WELWYN HATFIELD COUNCIL – DEVELOPMENT CONTROL
DELEGATED REPORT

APPLICATION No:	S6/2010/0008/LU
------------------------	------------------------

The proposal is for a two storey rear extension, a loft conversion incorporating a rear dormer window, a single storey side extension and a garage conversion into habitable accommodation. A new lower pitched roof is proposed on the proposed garage conversion.

CLIENT DESIGN SERVICES LIMITED. 8 Timberdene Avenue, Barkingside, Essex, IG6 2LS. Tel. 020 8550 3320	PROPOSED ELEVATIONS	Date	Jun. 2010
	PROPOSED EXTENSION AND LOFT CONVERSION AT 45 KENTISH LANE, BROOKMANS PARK, AL9 6NG.	Scale	1:100 @ A3
		Dgn. No.	C10/56/CLU 07 A

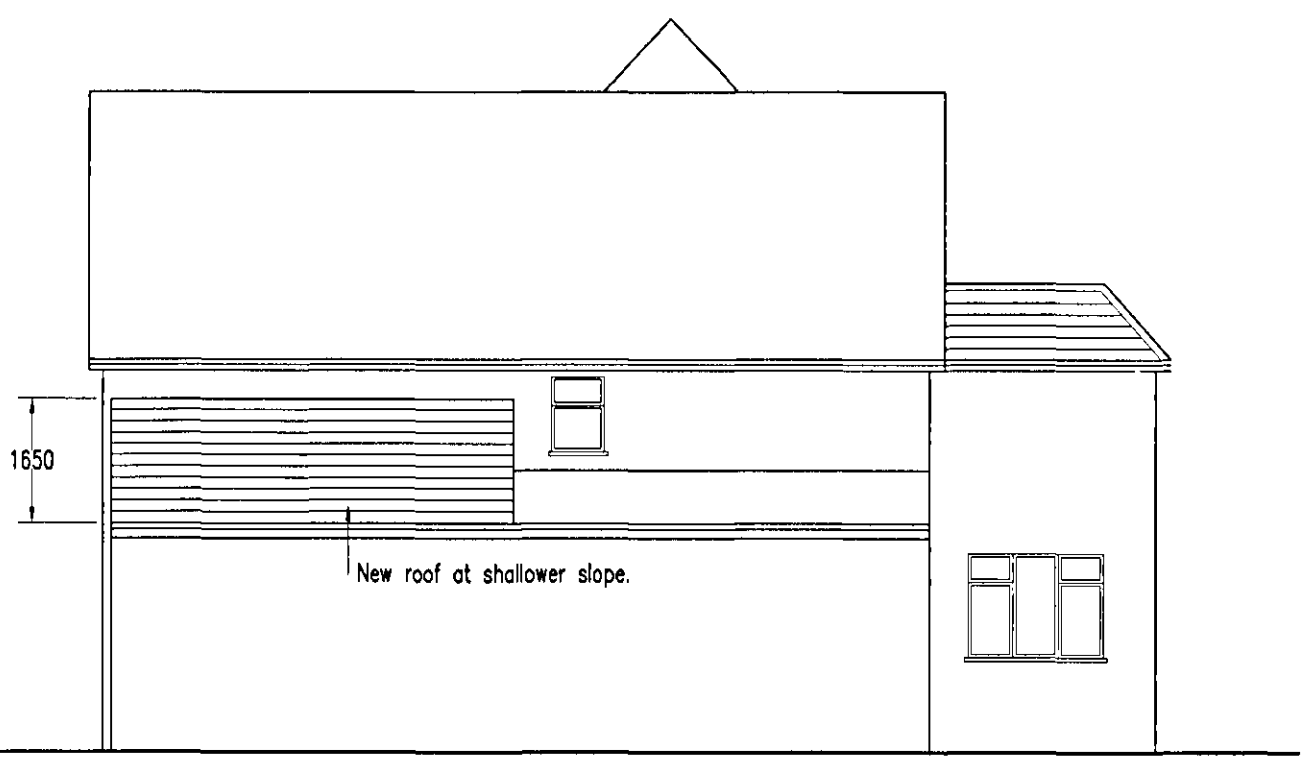
The two storey rear extension measures 3 metres in depth and measures more than 7 metres from the boundary when measured from the rear wall

The single storey side extension measures 3.7 metres in height and is less than half the width of the original dwellinghouse

The proposal does not include the installation, alteration or replacement of a microwave antenna, chimney, flue or soil and vent pipe. The proposal does however incorporate two 'Juliette' balconies within the rear elevation of the two storey rear extension. 'Juliette' balconies are generally considered permitted development provided there is no platform and therefore no external access. In this case, the proposal is considered to comply with class B (d) (i)-(ii)

The proposed pitch of the roof matches the pitch of the existing roof

CLIENT DESIGN SERVICES LIMITED. 8 Timberdene Avenue, Barkingside, Essex, IG6 2LS. Tel. 020 8550 3320	PROPOSED GROUND AND FIRST FLOOR PLANS	Date	Jun. 2010
	PROPOSED EXTENSION AND LOFT CONVERSION AT 45 KENTISH LANE, BROOKMANS PARK, AL9 6NG.	Scale	1:100 @ A3
		Dgn. No.	C10/56/CLU 05 A

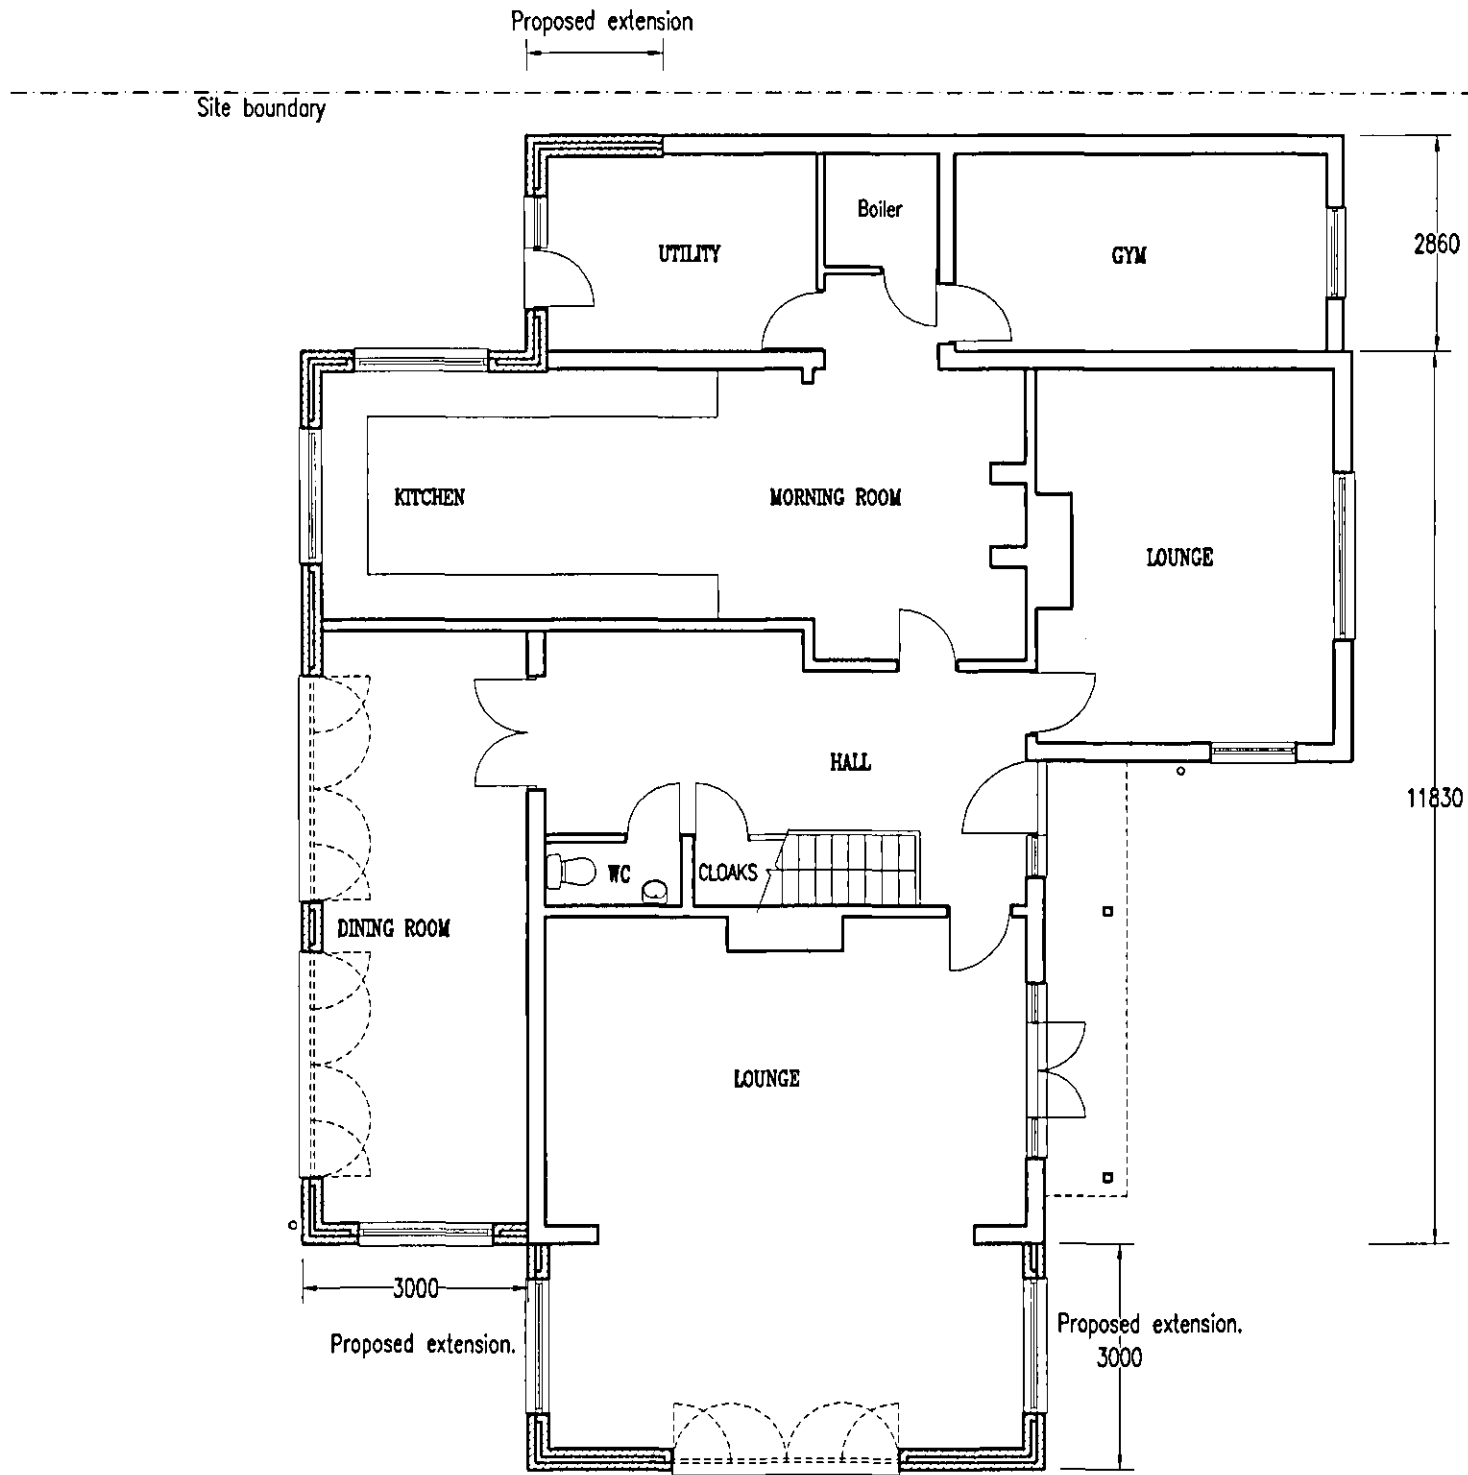
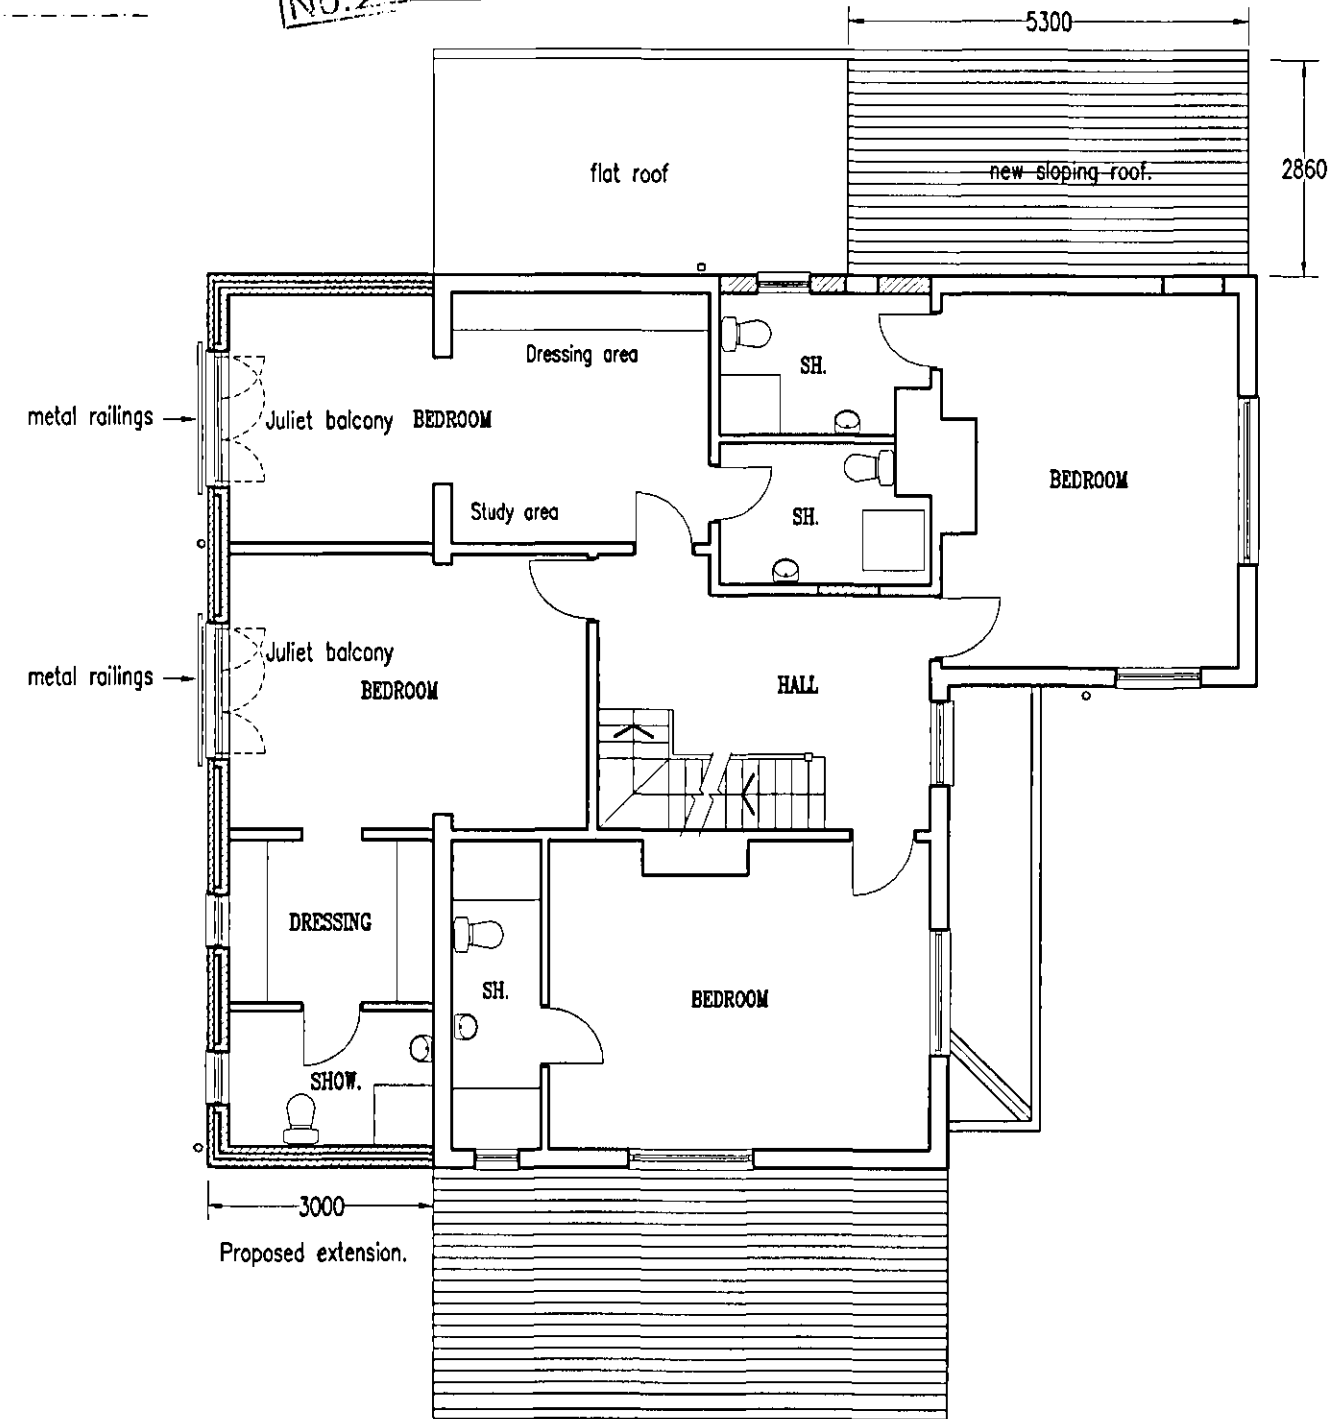
Roof above proposed garage conversion: (l) 5.3m x (h) 1.15m x (d) 2.8m / 2 = 8.5m³

CLIENT DESIGN SERVICES LIMITED. 8 Timberdene Avenue, Barkingside, Essex, IG6 2LS. Tel. 020 8550 3320	PROPOSED LOFT AND ROOF PLAN	Date	Jun. 2010
	PROPOSED EXTENSION AND LOFT CONVERSION AT 45 KENTISH LANE, BROOKMANS PARK, AL9 6NG.	Scale	1:100 @ A3
		Dgn. No.	C10/56/CLU 06 A

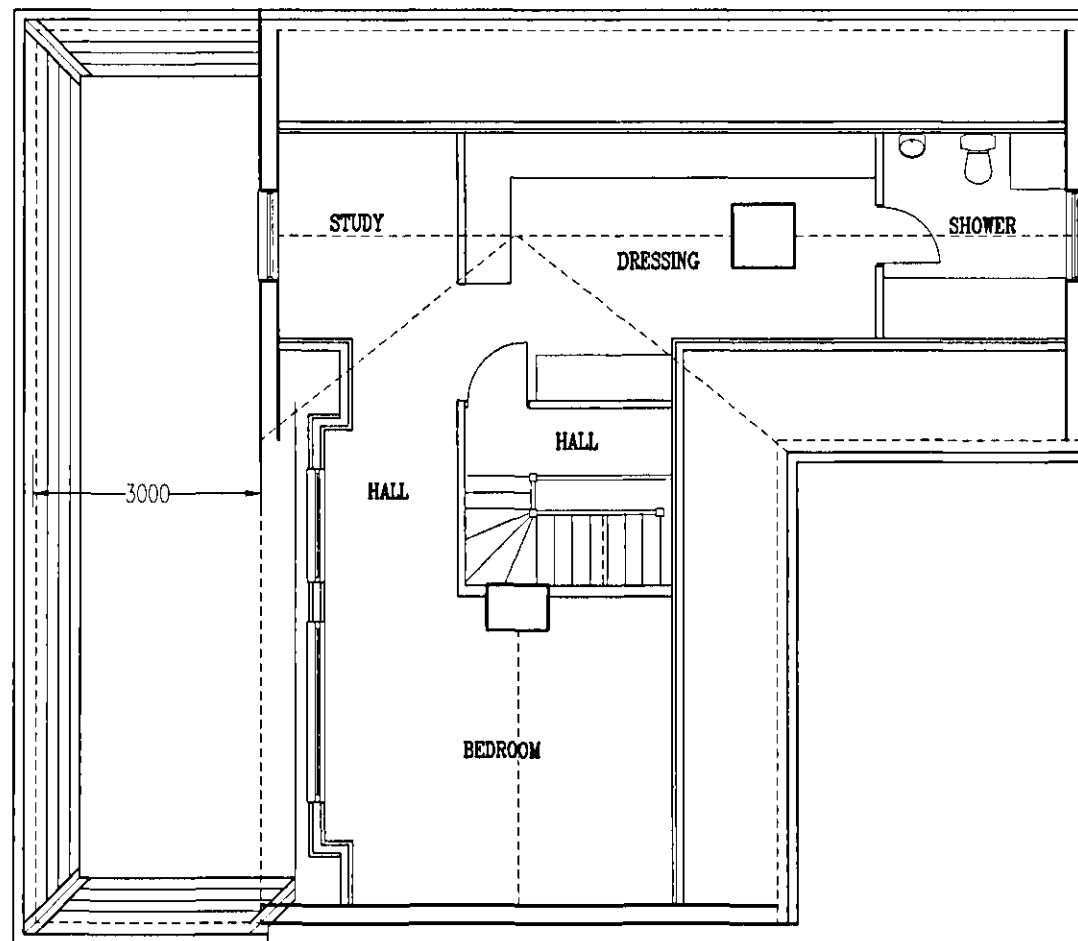
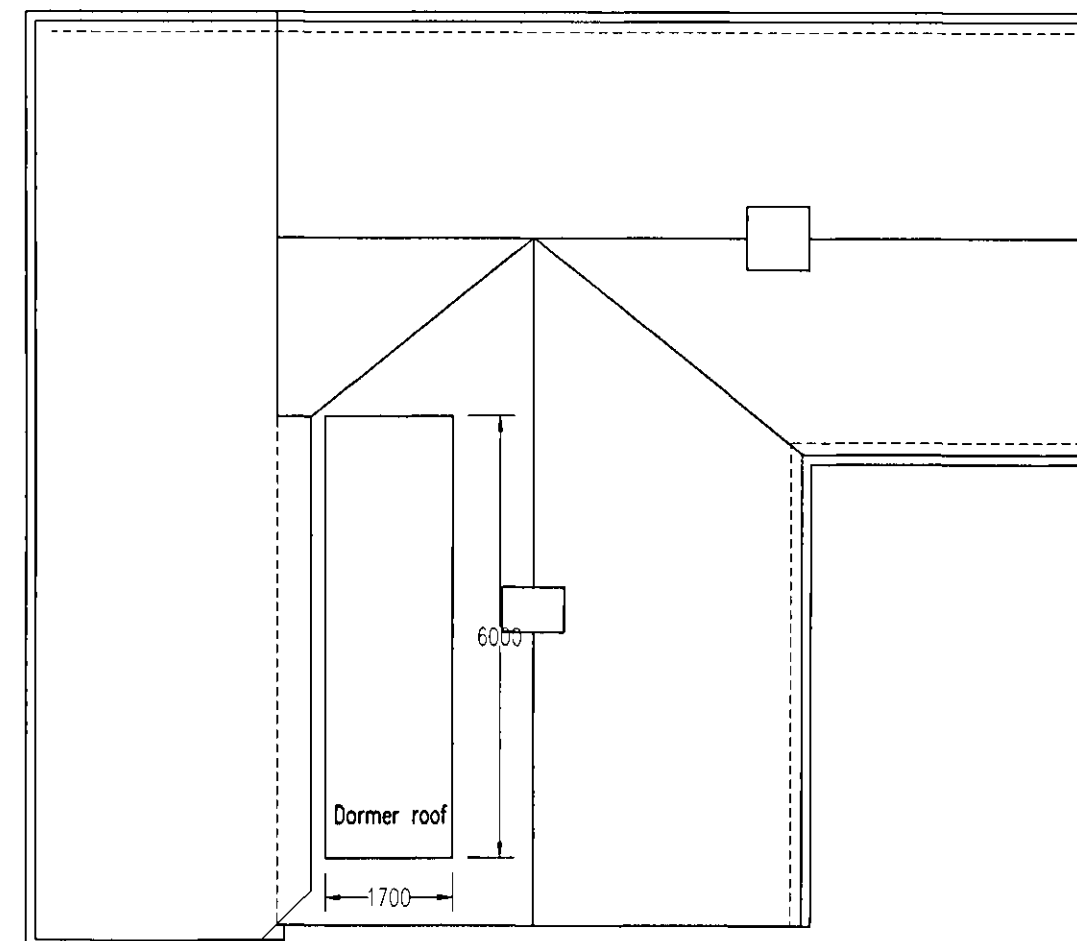
Proposed roofspace:

Rear Dormer window: (l) 5.8m x (h) 1.9m x (d) 1.45m / 2 = 7.9m³

Roof above two storey rear extension: (l) 11.3m x (h) 0.7m x 2.7m = 21.35m³

Roof above single storey side extension: (d) 6.8m x (h) 0.7m x (w) 2.8m = 6.6m³

*Total additional roofspace = **44.35m³***

The enlargement closest to the eaves of the original roof is no less than 20 centimetres from the eaves of the original roof.
